REQUEST

Current Zoning: N1-A (neighborhood) and MUDD-O (mixed-use development district, optional)
Proposed Zoning: MUDD-O (mixed-use development district, optional) and MUDD-O SPA (mixed-use development district, site plan amendment)

Approximately 4.57 acres located on the south side of Youngblood Road, east of McKee Road, and west of Buckthorne Ridge Lane.

The petition proposes expansion of an existing pet services indoor/outdoor use on current and adjoining site. The expansion will increase the size from 6,000 square feet to up to 8,500 square feet of gross floor area with additional limited outdoor pet services uses.

SHEET TITLE
REZONING PLAN: PETITION # 2023-007

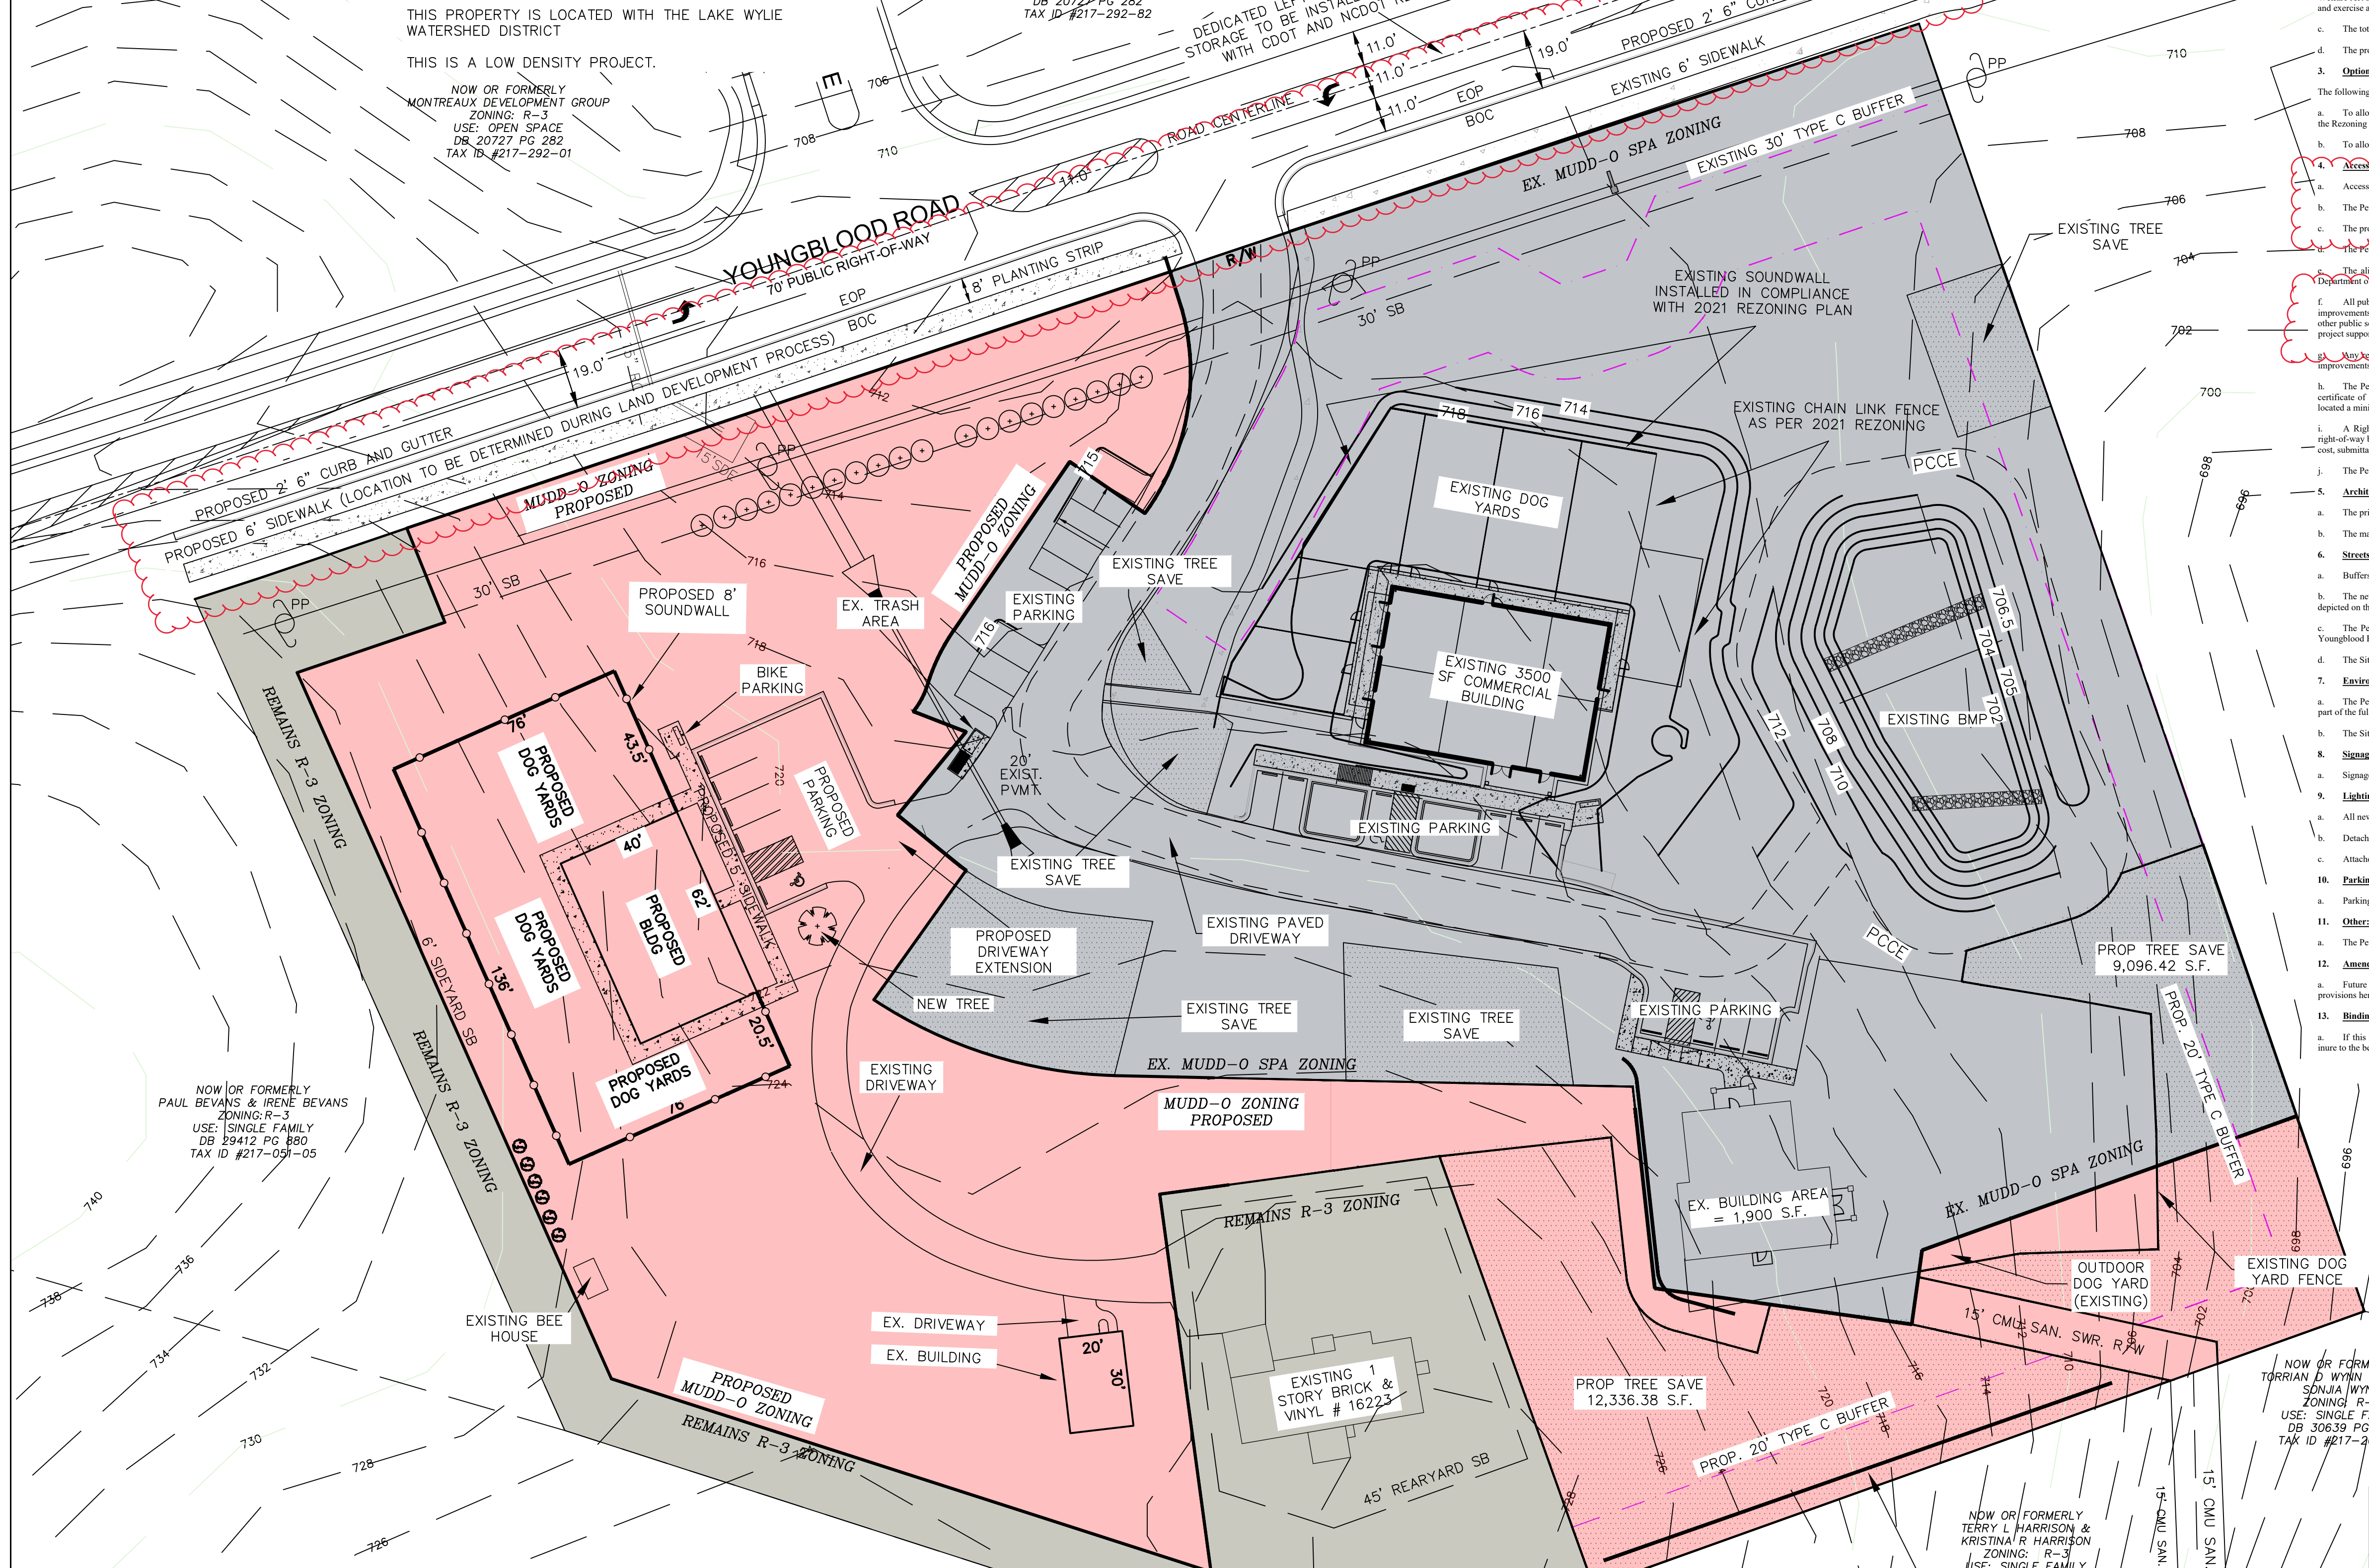
1. ~~Youngblood Road: Location of curb and gutter to be moved to 19 feet from roadway centerline to accommodate the Charlotte Streets Map with a roadway typical section of a 2+ avenue with an 8-foot planting strip and a 12-foot multi-use path. Label and dimension the curb and gutter from the centerline for each road on the site plan.~~ Addressed

2. ~~Revise site plan and conditional note(s) to commit to installing a left turn lane on Youngblood Road with 100 feet of storage.~~ Addressed
3. ~~Add conditional note specifying "All public roadway improvements will be subject to the standards and criteria of CDOT and NCDOT, as applicable, to the roadway improvements within their respective road system authority. It is understood that such improvements may be undertaken by the Petitioner on its own or in conjunction with other development or roadway projects taking place within the broad southwestern Mecklenburg area, by way of a private/public partnership effort or other public sector project support."~~ Addressed
